Application to replace existing timber fence to front boundary with a new brick wall (This application may affect the setting of a listed building).

26 Barrack Lane Aldwick

Thank you for your internet comments made on 31st March 2020 which has been recorded as **'no objection'** with the comments as follows:

PROJECT	26 Barrack Lane - Wall	DATE	20/02/20
TITLE	Plans and Elevations	DRG NO	IBA/533/02
SCALE	1 : 100	REVISIONS

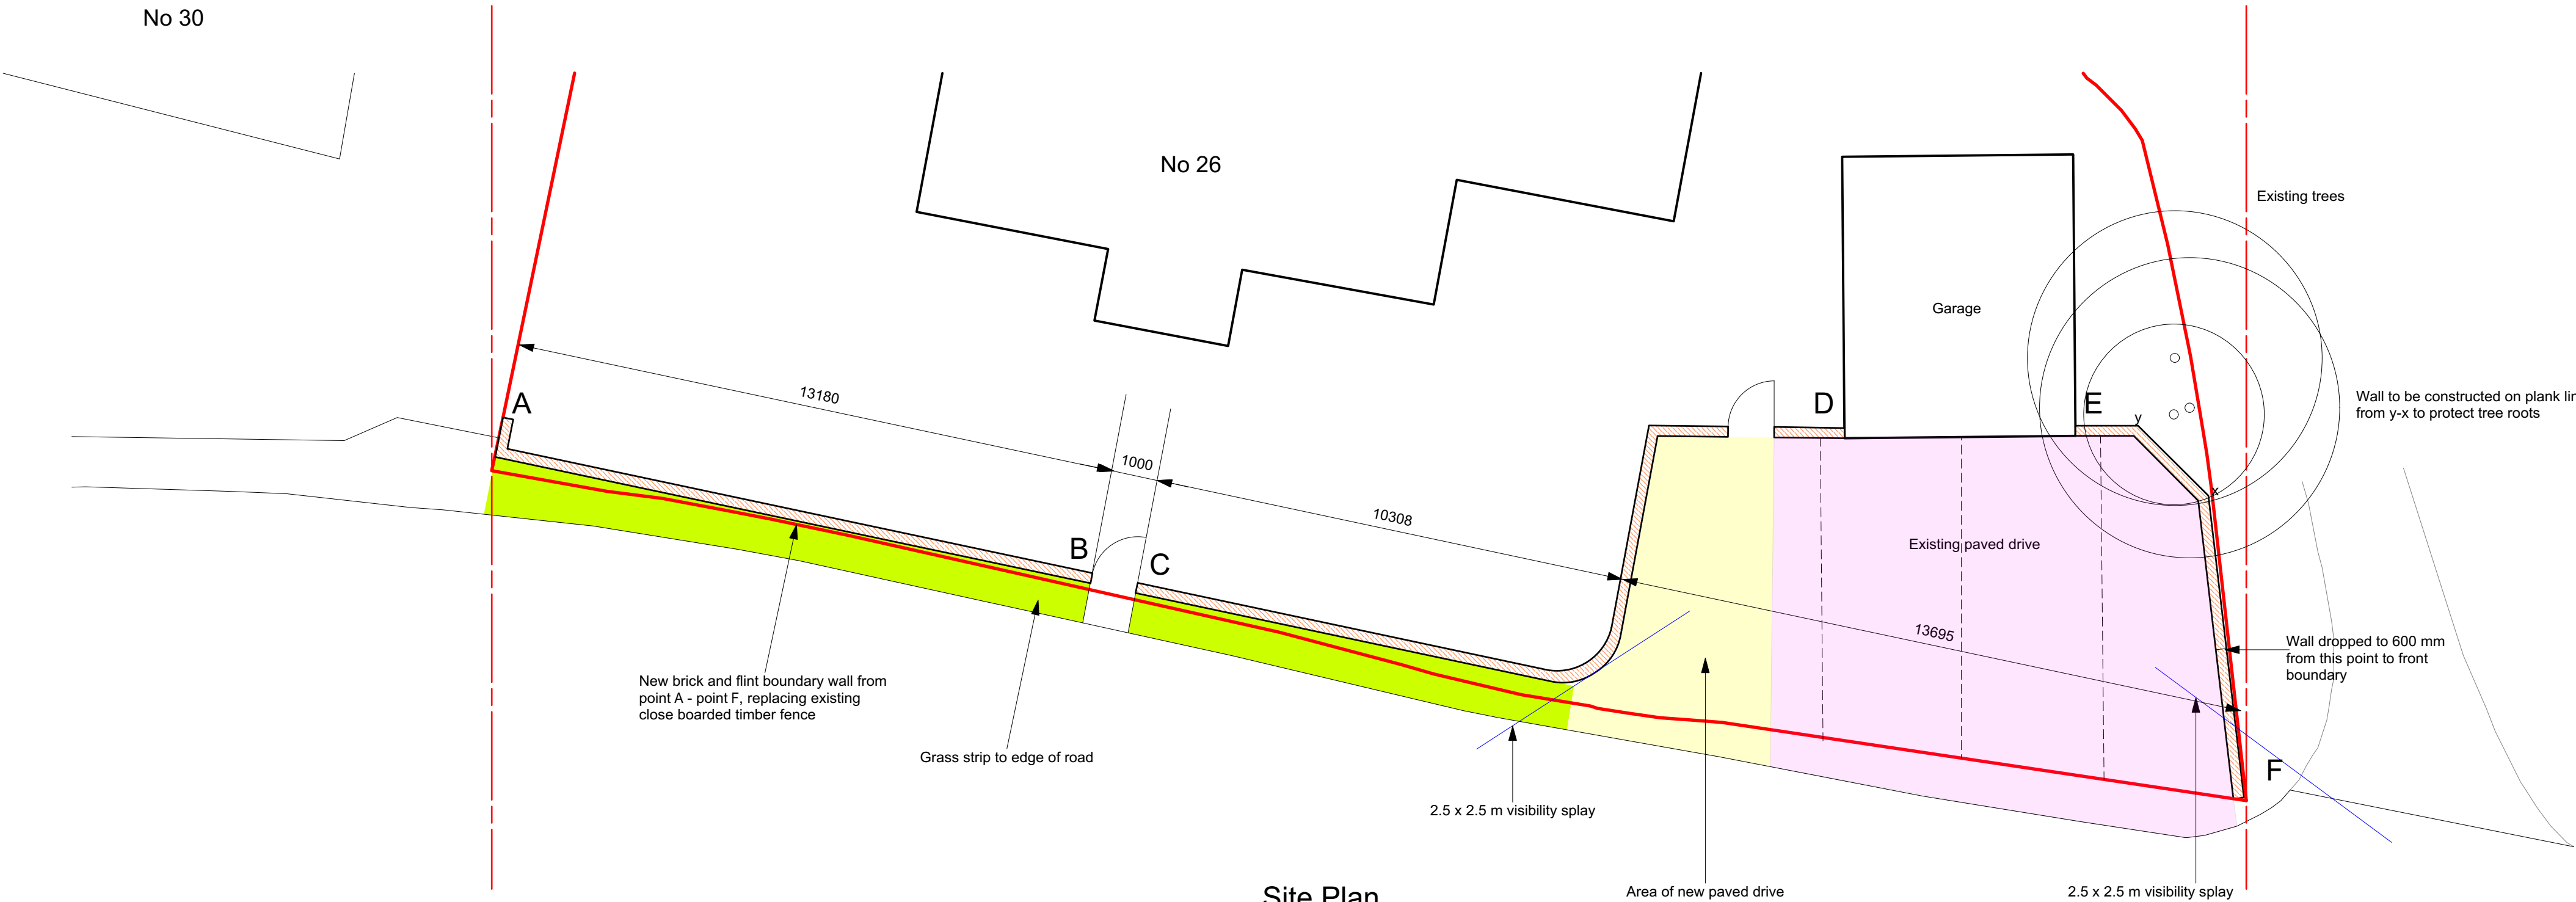
Members sent no objections to the application, however a Member stated that in relation to the wall, that a condition be set requiring the materials are as those shown on the plan so as not to compromise the adjacent listed building.
